Stockton Sand Quarry (DA140-6-2005)
Response to Submissions Additional Information

I refer to the Response to Submissions (RTS) submitted for the Stockton Sand Quarry. The Department is requesting you provide additional information before accepting the RTS.

Figure 1: location of AHIMS site relative to the 15 metre buffer (source: KNC, 2019)

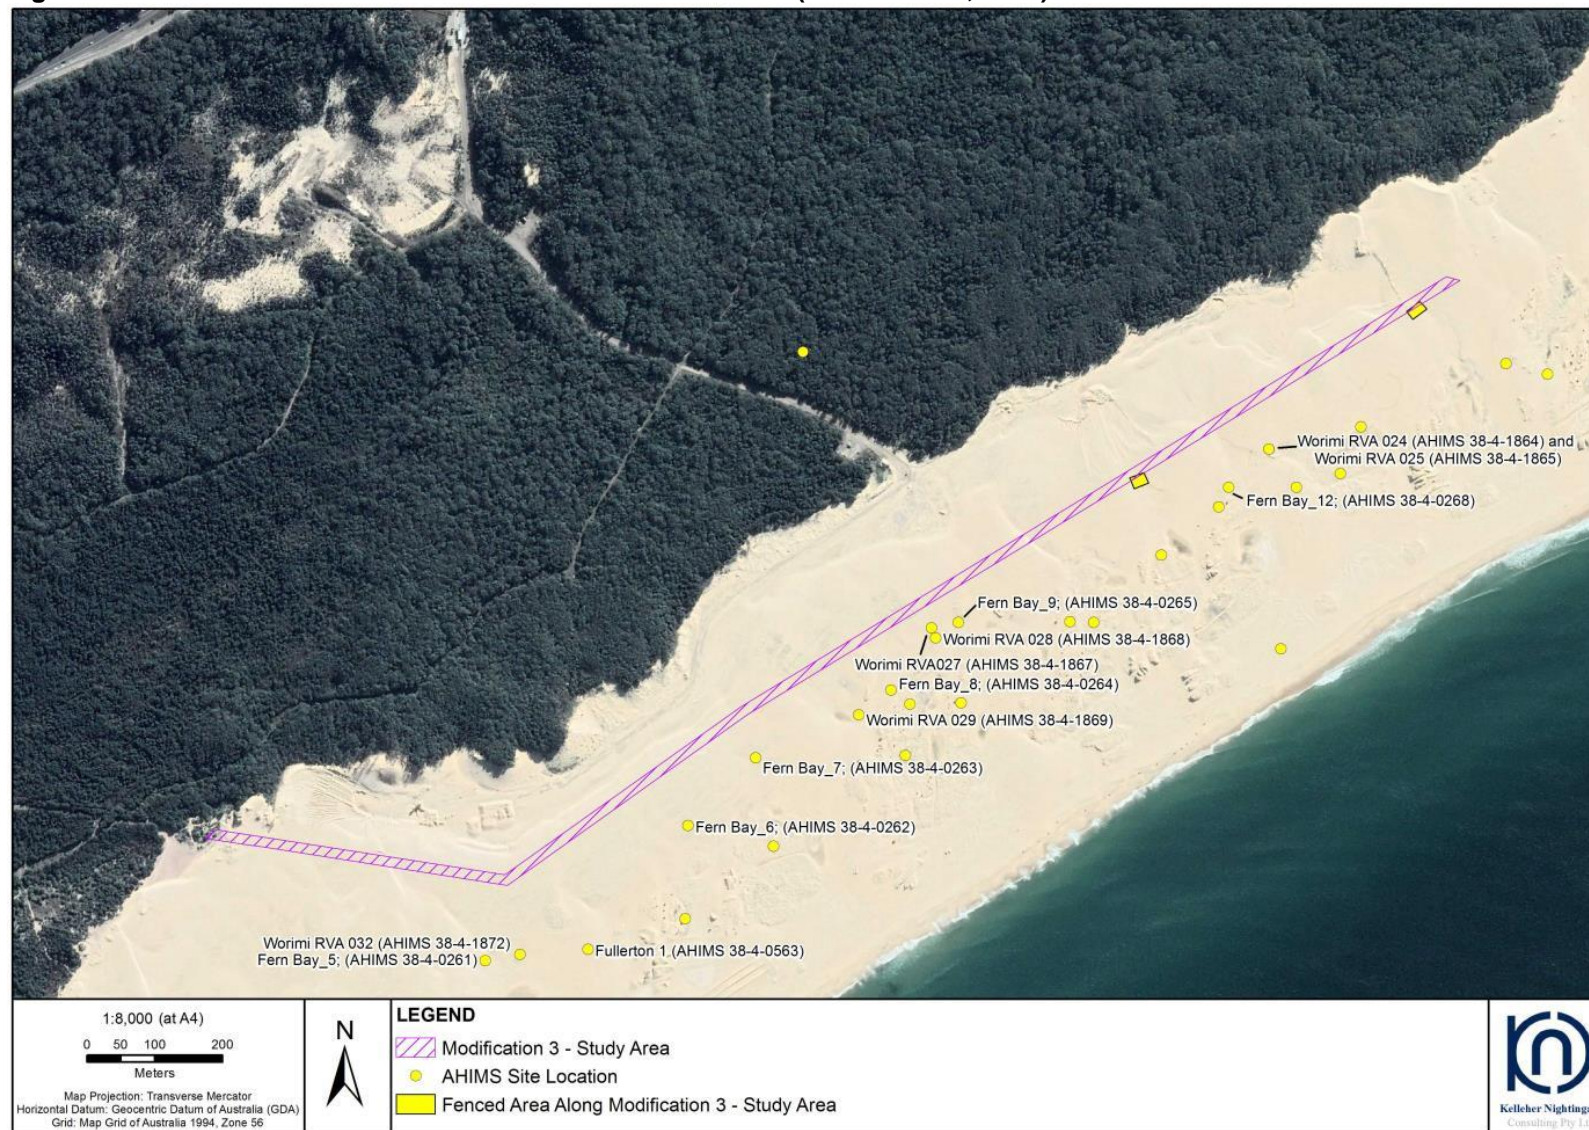
- Revision of Section 3.0 to remove the reference to Clause 55 of the *Environmental Planning Regulation 2000*; and
- Provision of a figure following Figure 1 that clearly shows the boundaries of the revised extraction area of the modification application.
